Re: Response to objections to Joe White Maltings proposed Malting Plant at Minto

This letter provides a response to the technical reports prepared on behalf of Lipa Pharmaceuticals Ltd (Lipa) in support of an objection to the proposed Joe White Malting Plant (JWM) at Minto. The reports were prepared by Mr Alex Jochelson of Pollution Control Consultancy and Design and Dr Richard Oppenheim, Principal of Dr Richard C Oppenheim. They relate to potential air quality impacts of the proposed plant on the Lipa plant which is adjacent to the JWM site.

**Figure 4 Predicted maximum 1-hour average NO<sub>x</sub> concentrations due to emissions from Joe White Maltings –  $\mu\text{g}/\text{m}^3$**

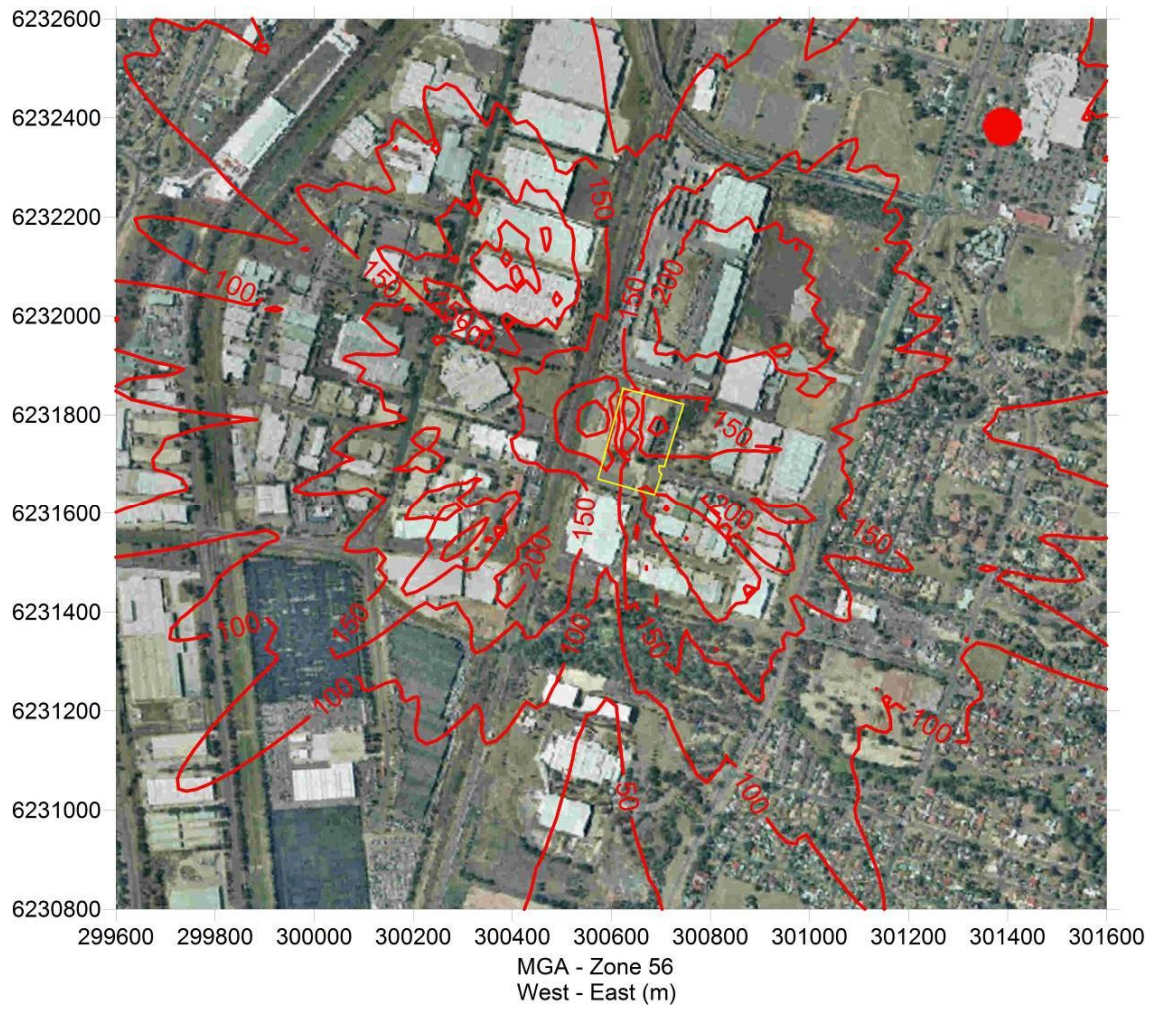
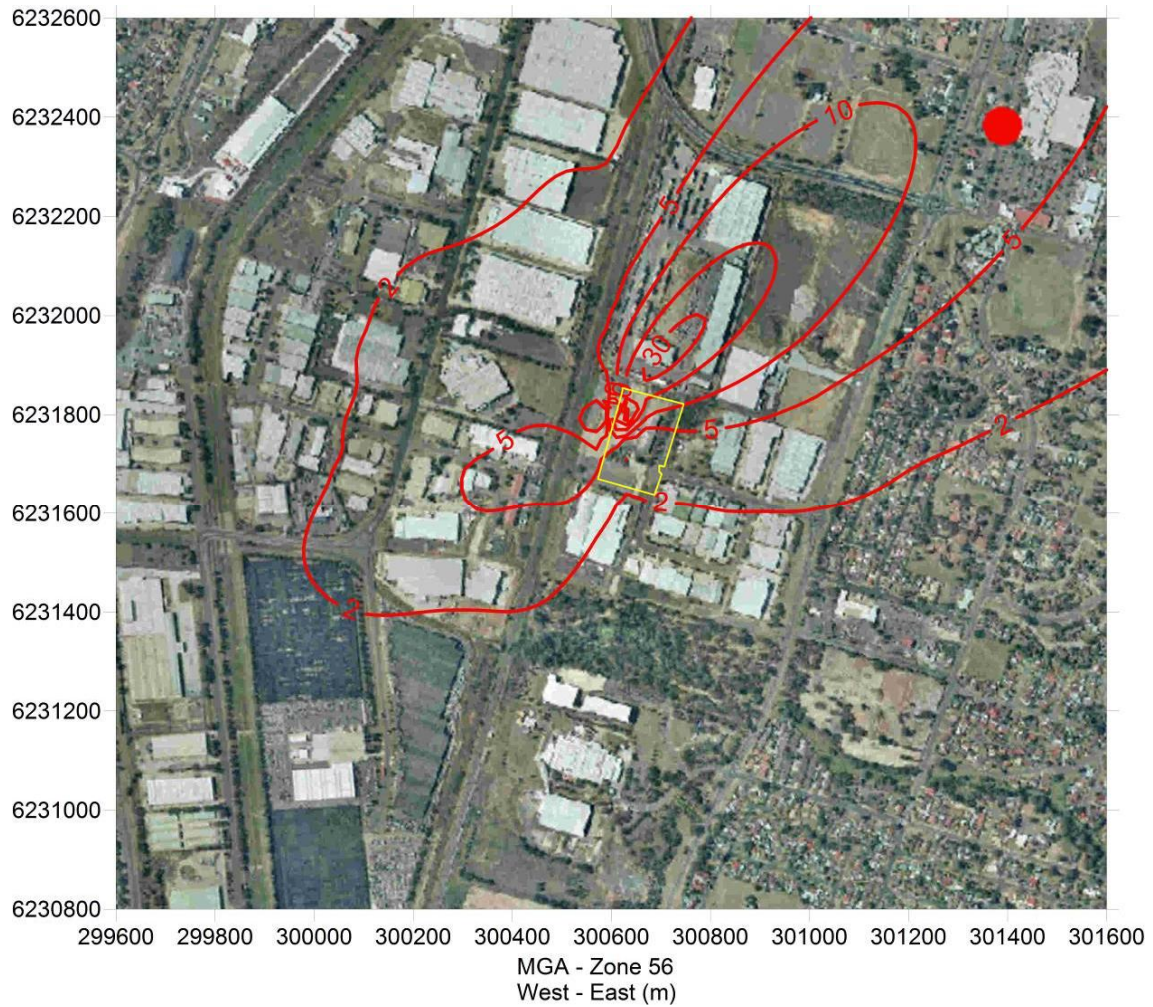
Modelling of oxides of nitrogen was originally carried for both a 50 m and 20 metre grid spacing. Building wakes were included in the modelling. An output file is attached with the details. The maximum predicted concentration of total NO_x was slightly less than 300 µg/m³ for both grid spacings.

We have also carried out a modelling runs with a 10 m spacing as suggested by Mr Jochelson and the maximum concentration is 310 µg/m³. Model runs were also carried out for heights above ground level of 3 and 6 metres and the maximum predicted concentrations were 301 and 310 µg/m³

respectively. Therefore the maximum predicted concentrations of NO_x at the Lipa site were captured in the original modelling.
